CHRISTOPHER
COWLEY AND
ASSOCIATES

DA/22/00811/FUL – No 283 Lowfield Street, Dartford, Kent DA1 1LB

Our client received the Notification of Refusal of her previous Planning Application dated the 9th of December 2022

PROPOSED ELEVATIONS AND SECTION B-B
New 3 Bedroom house to be built on vacant (garden)
land towards the side of the existing house.

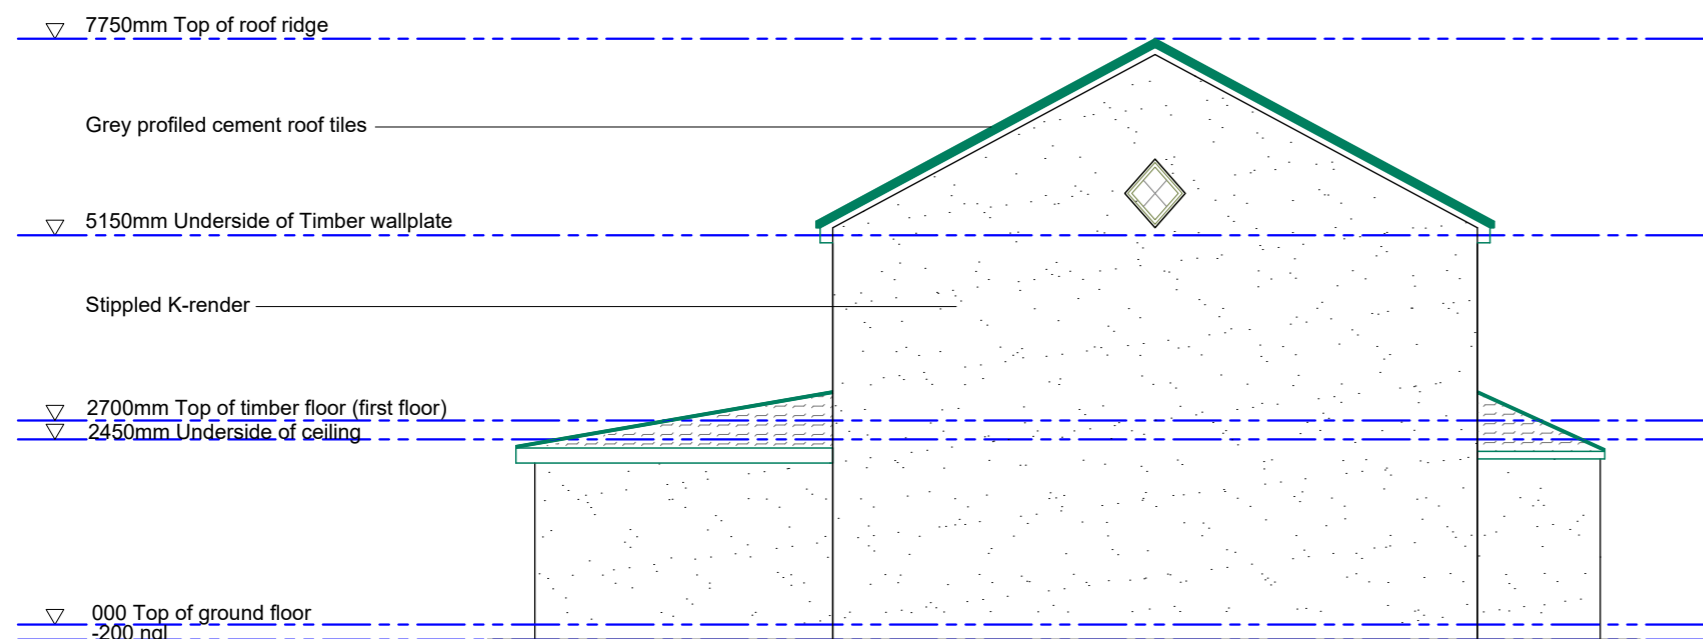
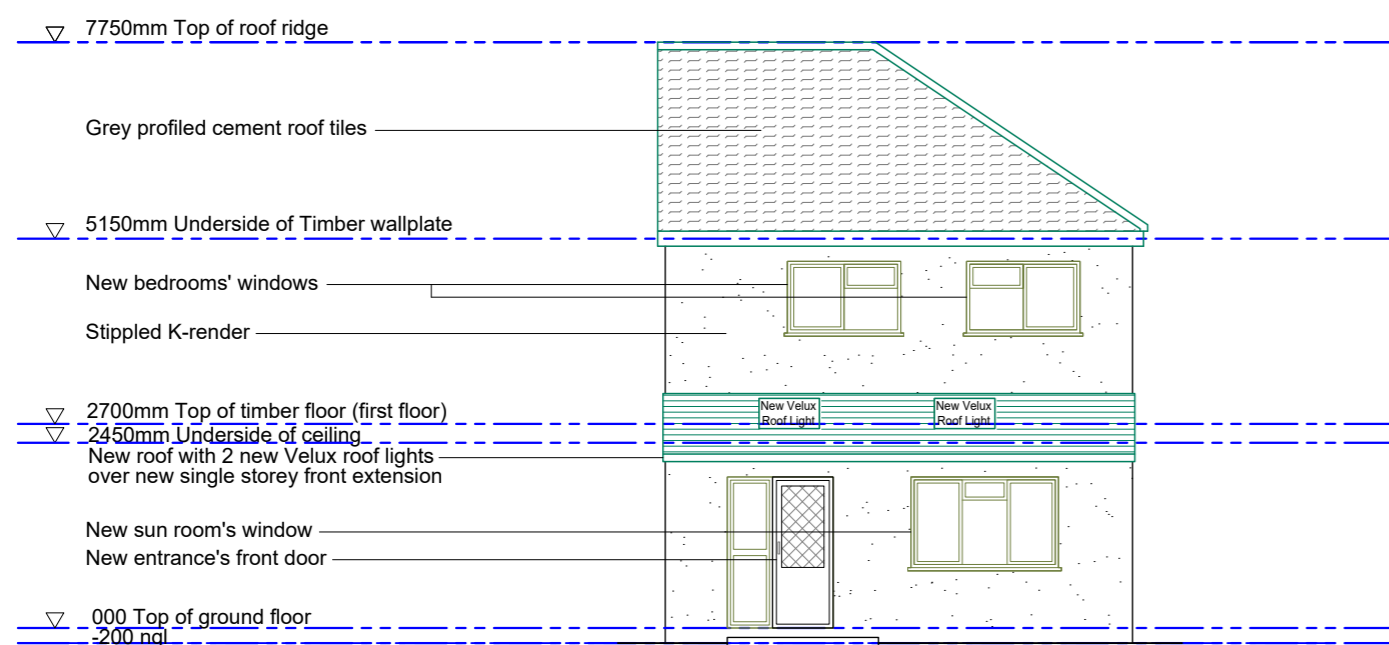
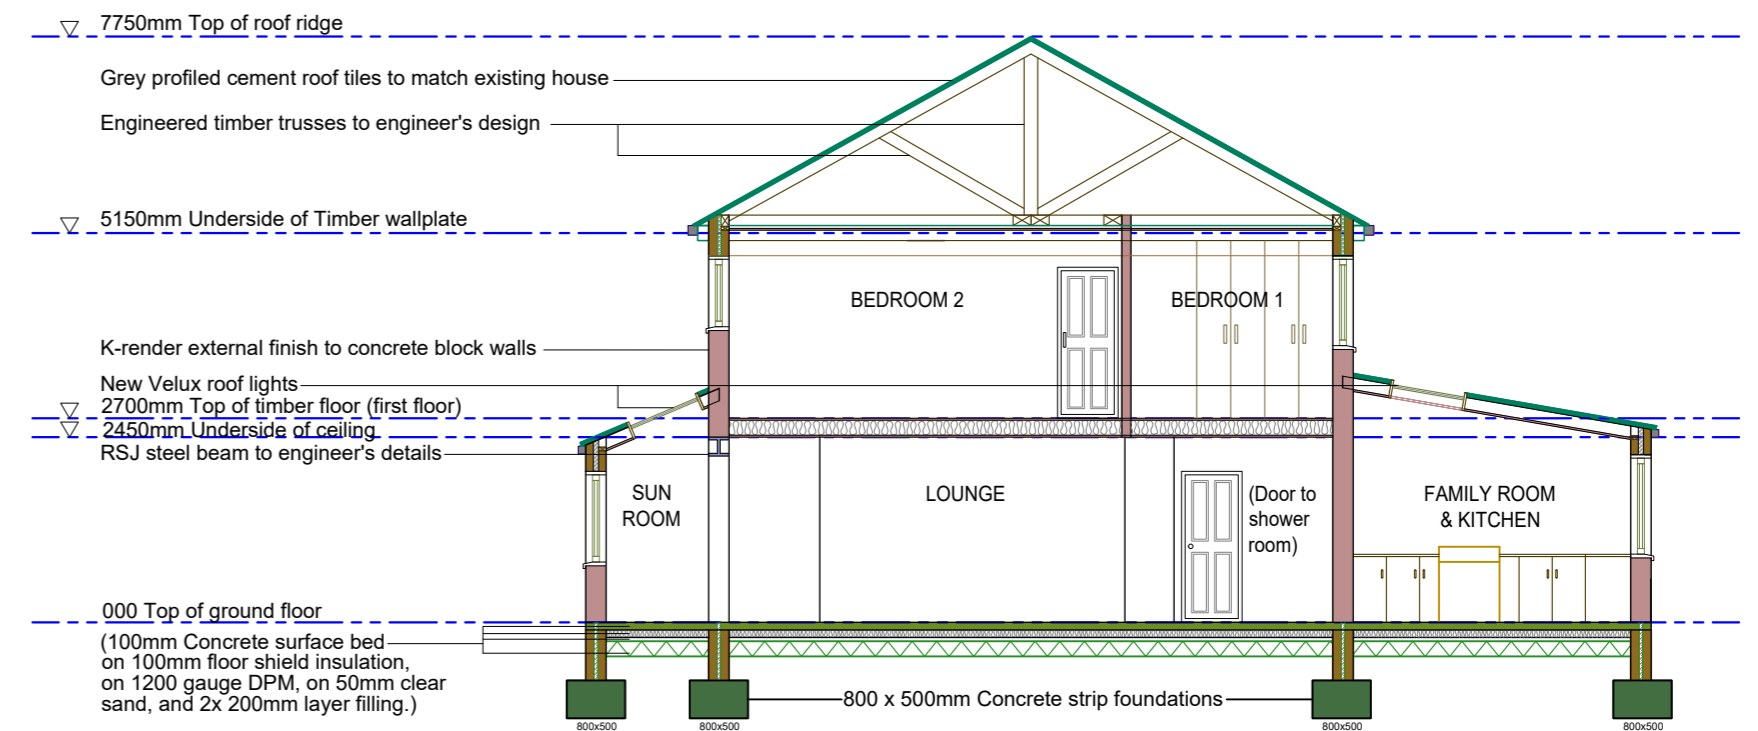
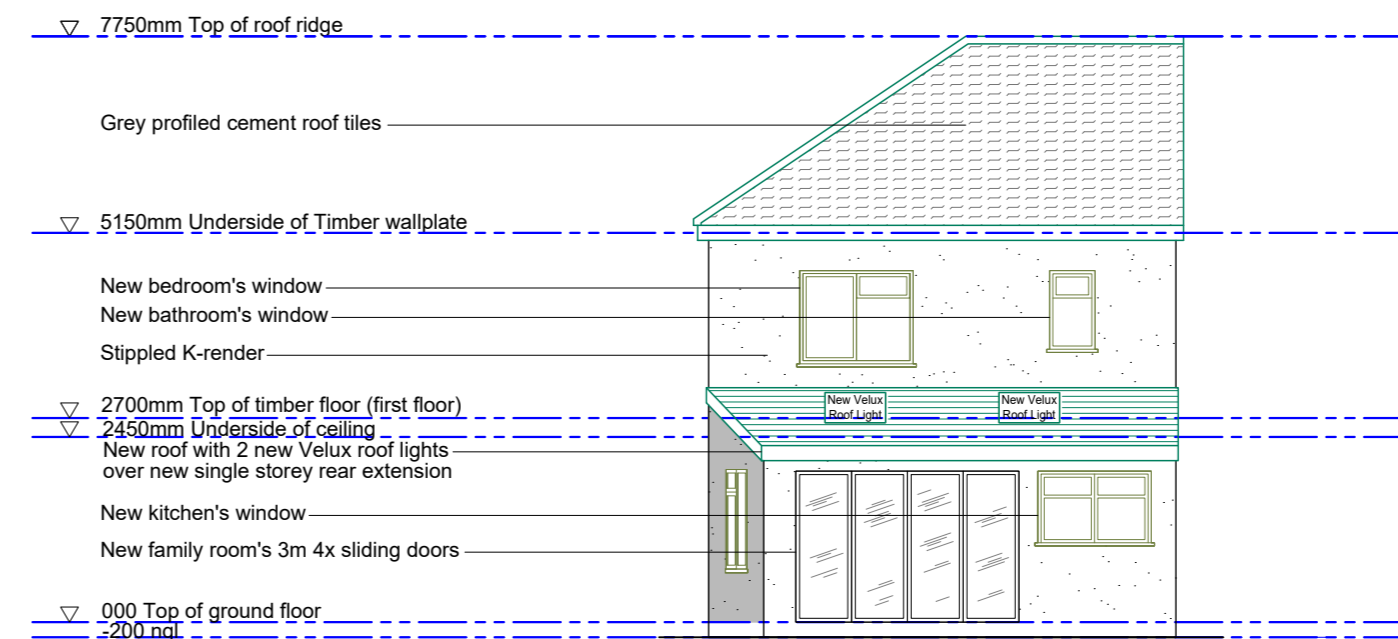
D04 D Proposed Elevations & Section BB; P BP Proposed Block Plan Final; D03D REV D Proposed Site, Floor & Roof Plans & Site Location Plan And that the grounds for such refusal are:-

The proposed house is of the same profile, design, materials and character of all the existing houses in the group and the street. How can it possibly cause “harm to the character of the area?”

PROPOSED SITE, FLOOR AND ROOF PLANS  
New 3 Bedroom house to be built on vacant (garden)  
land towards the side of the existing house.

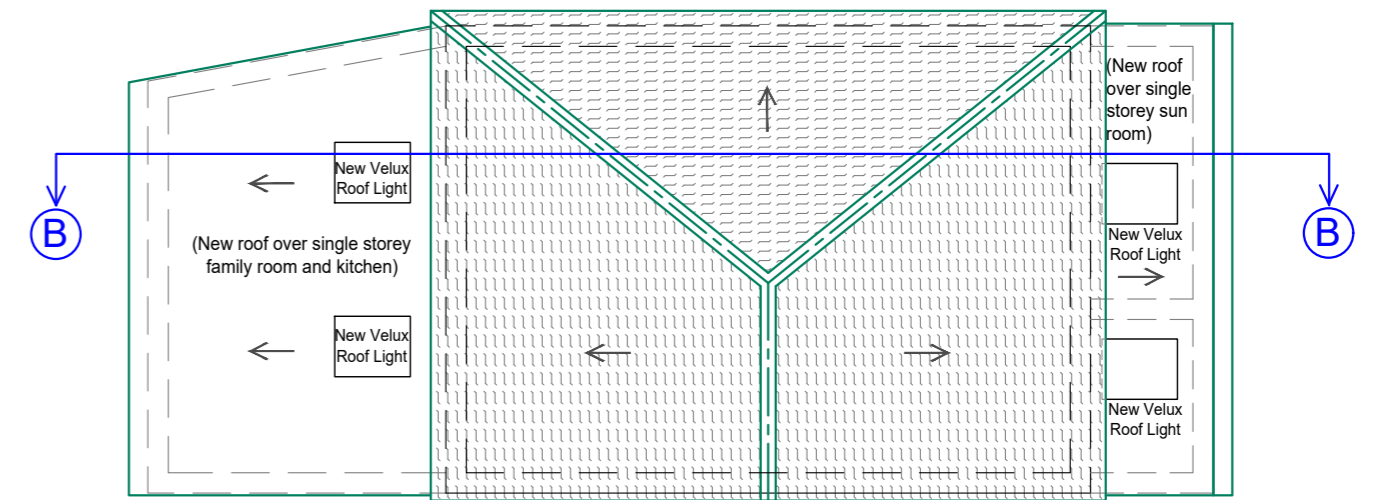
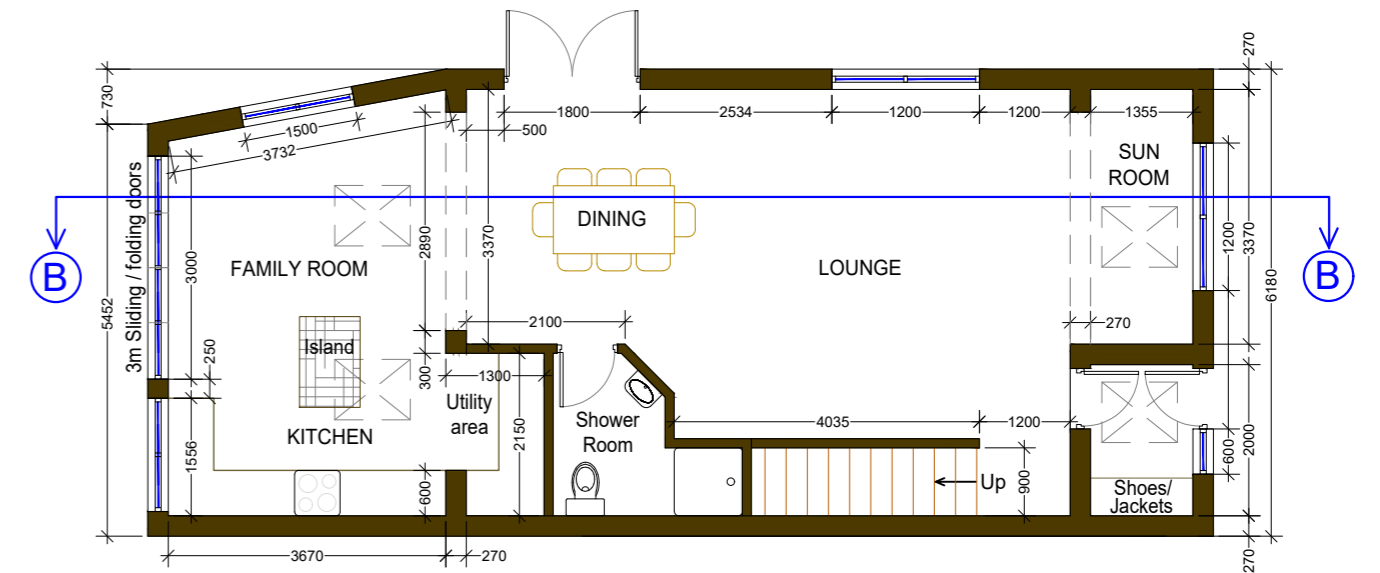
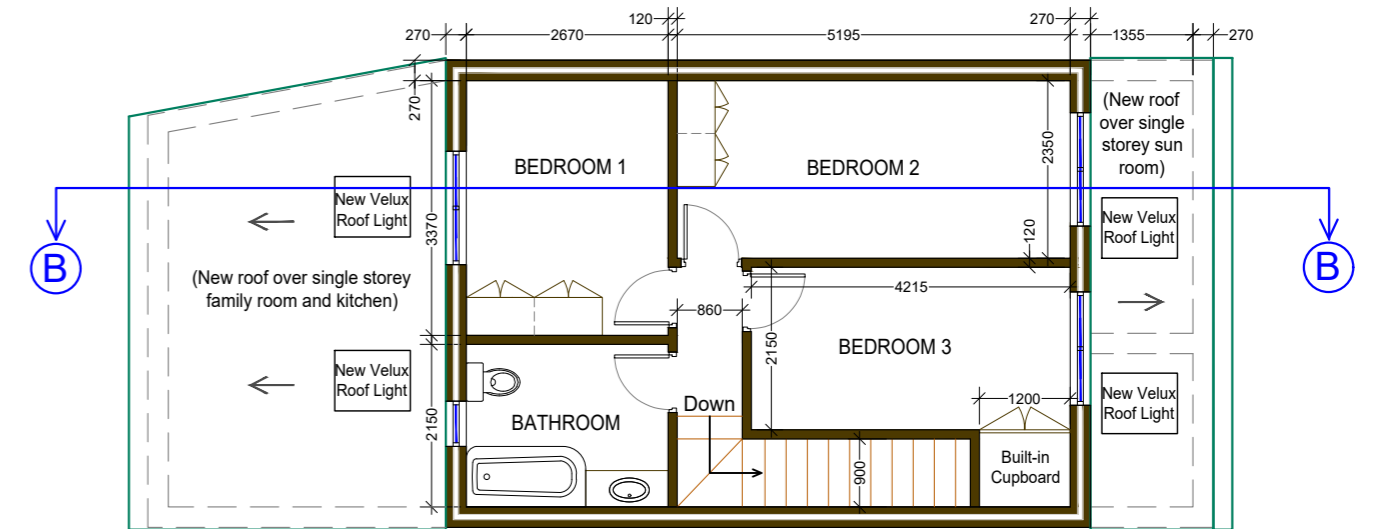
The disbenefits of the development therefore clearly outweigh the benefits of developing this windfall site in terms of the loss of garden land, severe reduction to No.283's amenity space which is harmful to their amenities, the harm to the character of the area, poor

quality garden space for the new dwelling, unsatisfactory access and insufficient parking provision. As such the development is contrary to policies CS1 and CS10 of the Core Strategy, Policies DP2, DP4, DP5, DP6, DP7 and DP8 of the Dartford Development Policies Plan and M1, M2, M9, M10, M11, M16 and M17 of the emerging draft local plan.

02 The proposed parking for 283 Lowfield Street, by virtue of the width of the footway and lack of turning space within the site would lead to vehicles turning on the footway thereby compromising pedestrian safety. This is contrary to adopted policy DP4 and M16 and M17 of the emerging draft local plan.

The parking arrangements could easily have been resolved if any meaningful conversations were held with the applicant and/or her representative(s). A simple solution will be to provide access and parking at the rear of both properties off the side road i.e Myrtle Road. Our client will be happy to accept it as a condition had the Council communicated or asked for it. She is still willing to accept and provide parking in this manner.

Note : Our client has addressed this issue in the new layout as contained in this new Resubmission.

The proposed garden space allocated to the original house known as No 283 Lowfield Street, Dartford DA1 1LB is actually significantly larger than that of adjoining properties no's 286, 287, 291, 293, 297 etc and no's 278, 280, 282, 284, 286, 288, 290, 292 and 294 further up on the opposite side of the street as shown on the Site Locality Map as submitted. This is just to mention a few examples in the same street.

The garden of the proposed new unit will be at least 80 square metres larger than that of the remaining original unit. This reason for refusal is ill-considered, arbitrary and simply not accurate.
